## Technical Note

Project No: ITB13091  
Project Title: Ford Airfield – The Landings  
Title: Sustainable Accessibility Addendum Note  
Ref: 13091-029  
Date: 5 August 2020

- 1.1 Planning application F/4/20/OUT has been submitted to Arun District Council for consent for development of up to 1,500 dwellings, 60-bed care home, up to 9,000sq of employment floorspace, local centre of up to 900sqm of retail commercial and 1,450sqm of community/leisure floorspace, land for a two-form entry primary school, public open space, allotments, new sports pitches and associated facilities, drainage, parking and associated access, infrastructure, landscape, ancillary and site preparation works, including the demolition of existing buildings and part removal of existing runway hardstanding.

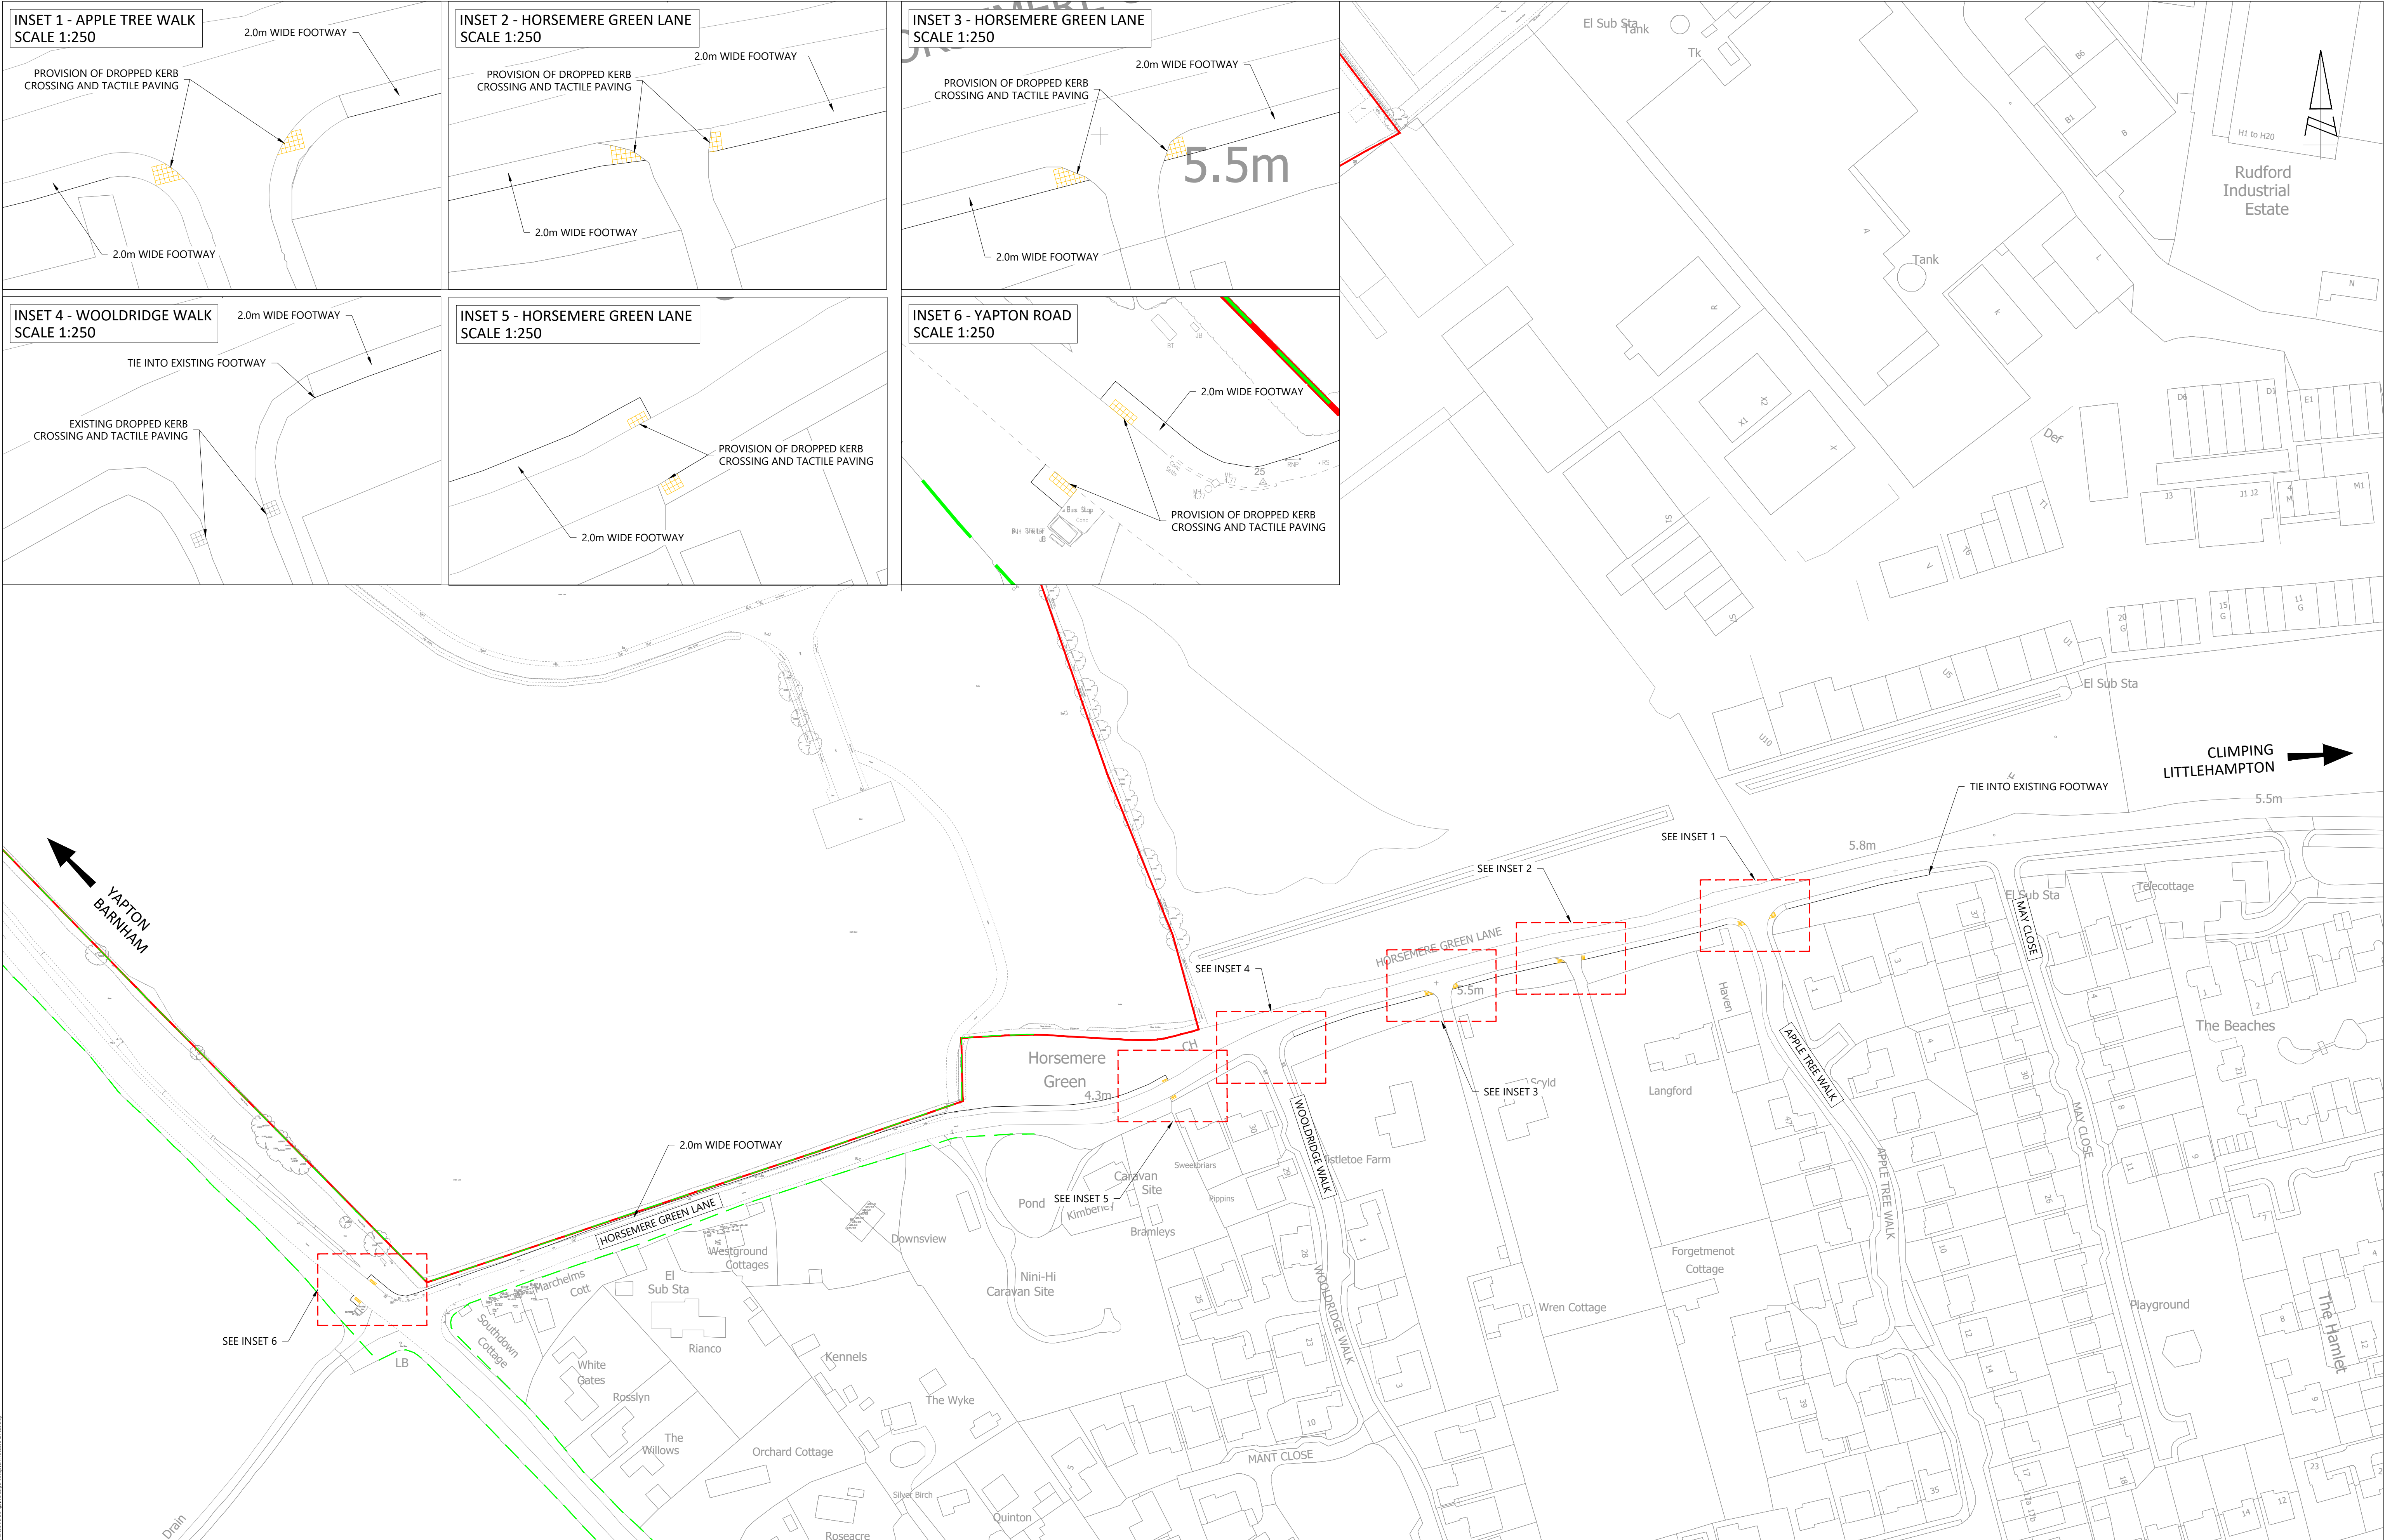
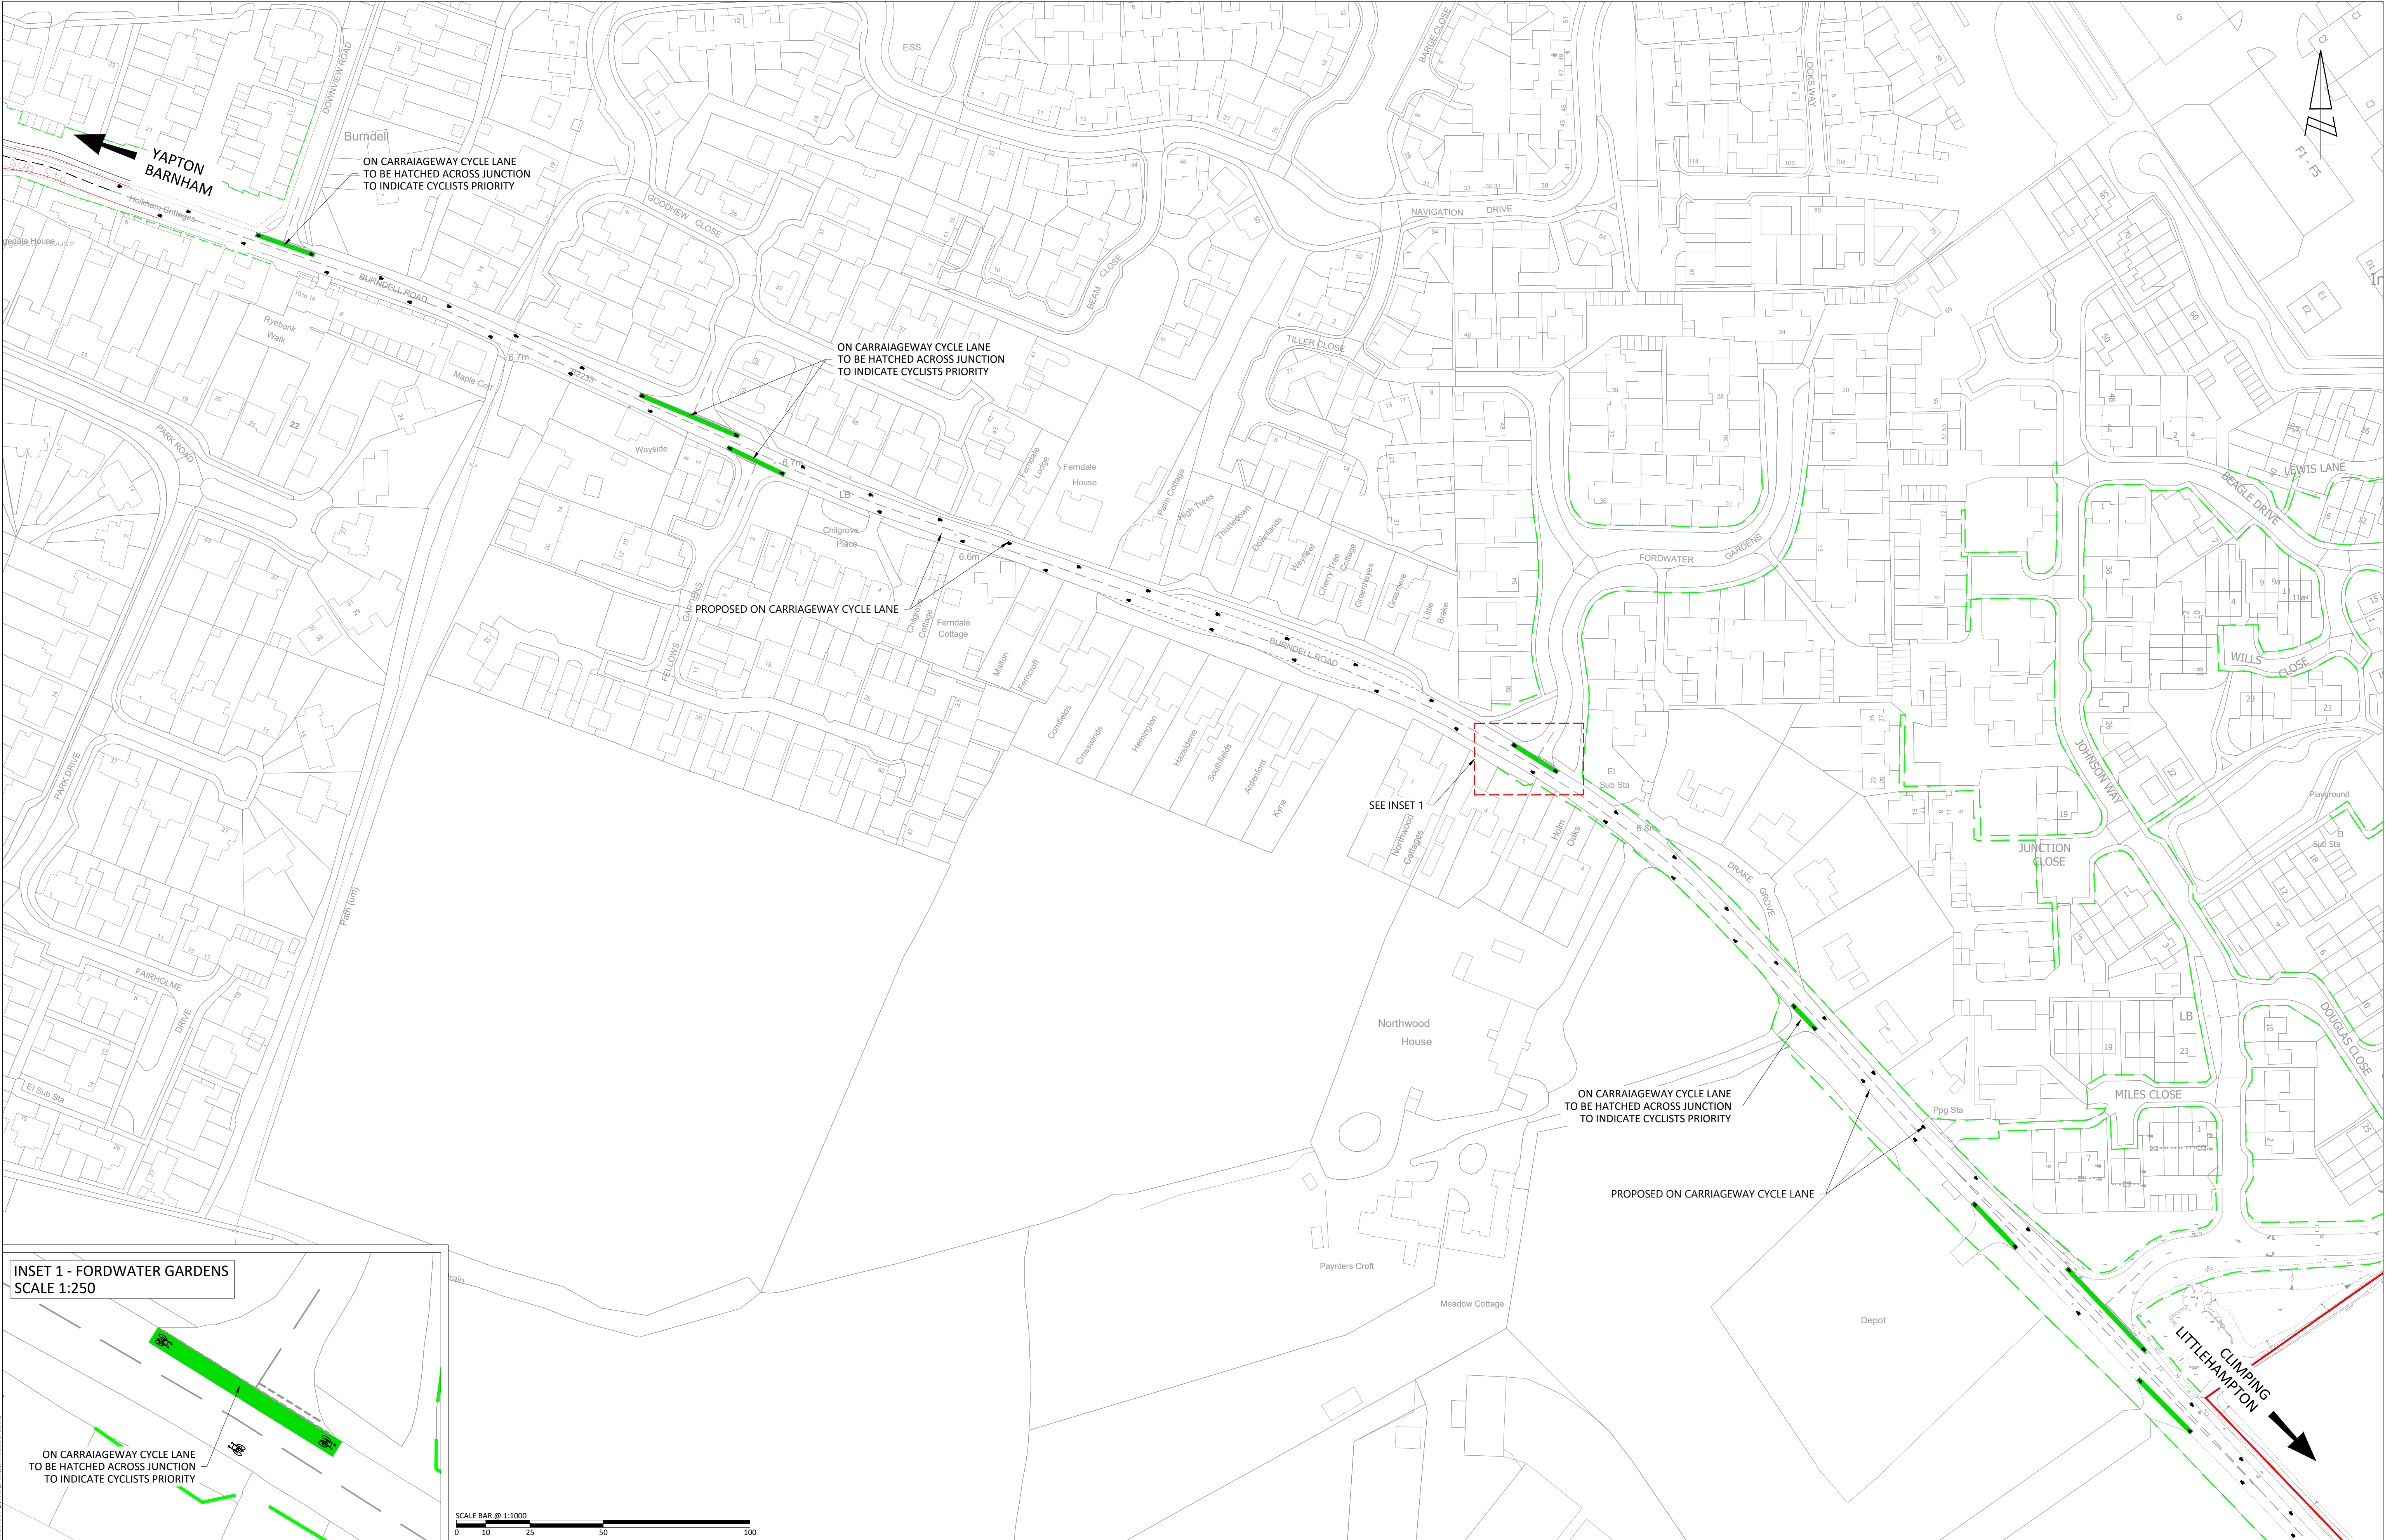
- 3.1.1 WSCC has requested that further consideration be given to provision of cycle facilities between the development site and Yapton.
- 3.1.2 It is not possible to provide an off-road route along the B2233 due to width constraints along the corridor as a result of private property being located on both side of the road. As recognised in Chapter 3 of the CDG, it is recognised that it will not always be possible to retrofit new infrastructure into the existing highway network in accordance with the design guidance contained within the document due to such constraints. The CDG advises that, in such instances, the design should be considered on a site-specific basis.

- 3.1.3 The B2233 is subject to the carriage of buses services and therefore it is necessary to retain a carriageway width of at least 6m in order to effectively accommodate these services; in doing so, it would only be possible to provide cycle lanes circa 1m in width. Table 2a of the CDG sets out that a width of 1.7m would be required to provide for an absolute minimum effective width of 1.5m. In such circumstances, the CDG advises that where the minimum width cannot be attained over the majority of its length then cycle lanes should not be provided. Alternatively, cycle signage and demarcation should be used.

- 3.1.4 On this basis, a scheme of improvements has been prepared and are shown in **Drawings ITB13091-GA-059, 060 and 061**. The scheme comprises signage of a cycle route to Yapton from Rollaston Park with on-carriageway cycle logo demarcation situated 1.5m from the kerb at 25m intervals. In addition, green coloured surfacing is provided across junctions to reinforce the potential presence of cyclists and minimise the risk of conflict arising from vehicles overshooting the give-way line/creeping into the carriageway from a side road.

- 3.1.5 The scheme of improvements has been shown to extend from Rollaston Park in the east to Yapton Village Hall in the west, directly west of the Bilsham Road/B2233 mini roundabout. In addition, the route extends south from the Bilsham Road/B2233 mini roundabout to Mill View Road to provide a connection to potential onwards facilities secured through planning consents Y/91/17 and Y/92/17.

| DRAWN:                         | CHECKED:              | APPROVED:         |
|--------------------------------|-----------------------|-------------------|
| DRAWING No:<br>ITB13091-GA-061 |                       | REV:<br>          |

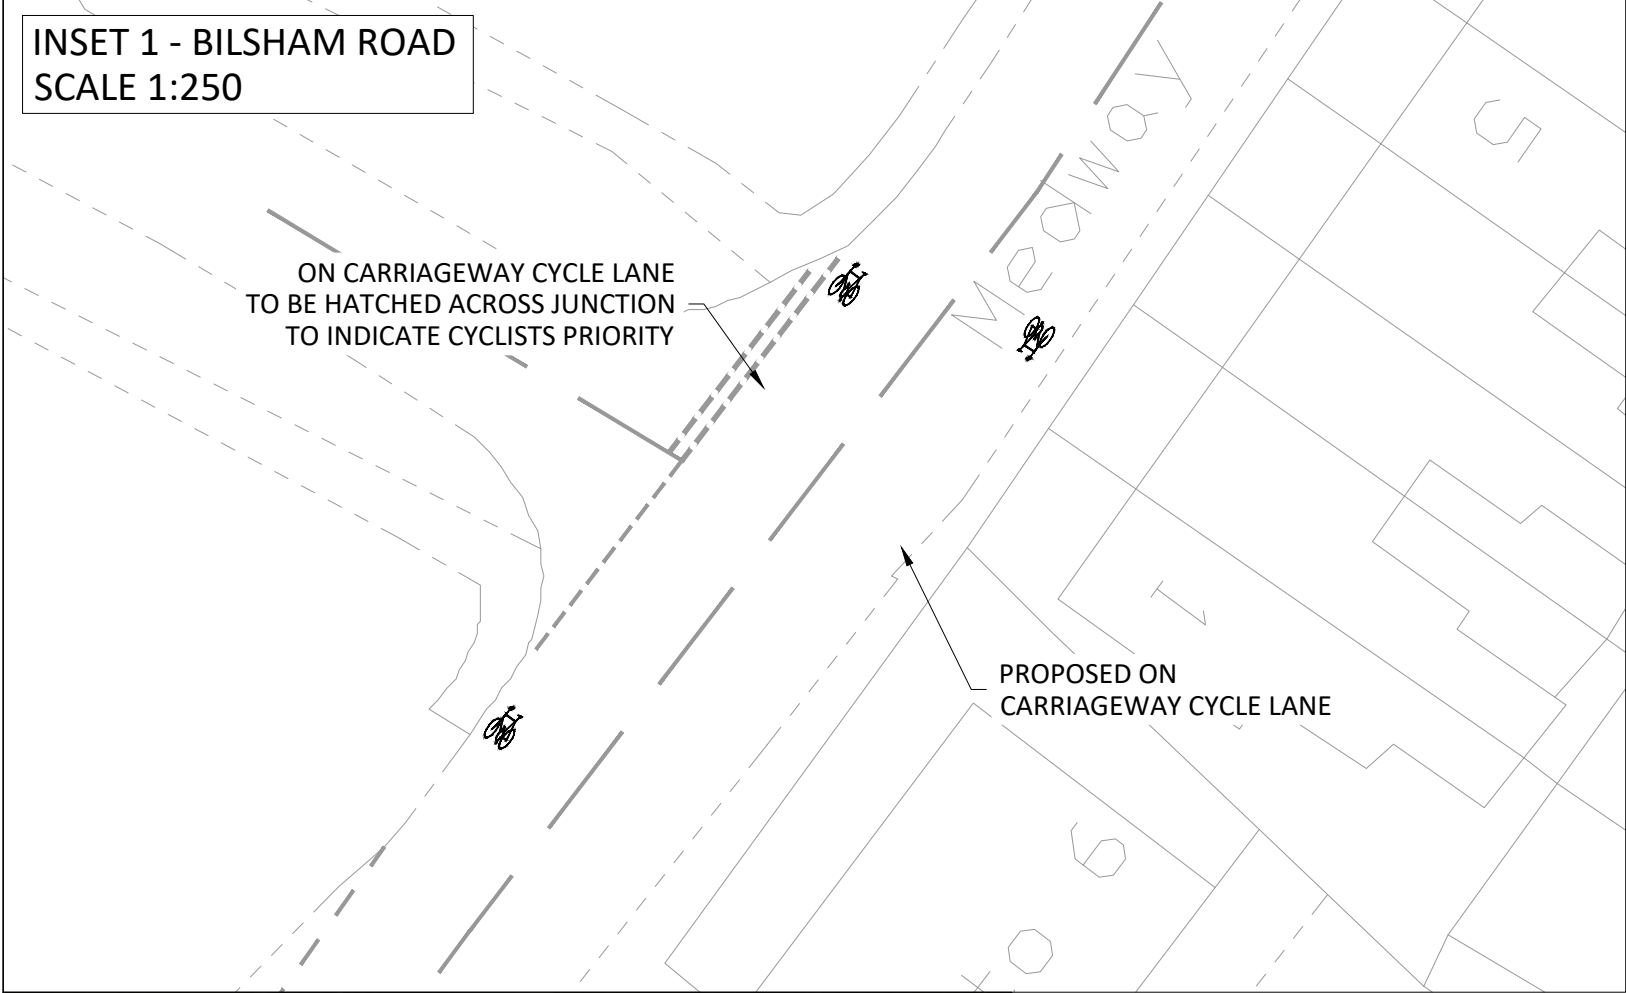
- 3.1.6 At this time no signage has been shown along the route, as the directional signage would be affected by the onwards facilities available at the time of implementation. However, an illustrative sign is shown in Drawing **ITB13091-GA-061** to define the type of signage that would be included along the route.

The signage, as well as other factors such as the location where which the route terminates (it is noted there are multiple potential routes for the Yapton-Barnham cycle route) and the intervals at which the cycle demarcation is placed, would be further refined through the detailed design process. The proposed scheme of works is intended to provide an illustrative arrangement to agree the scope of the scheme for the purposes of agreement through planning condition/S106 Agreement.
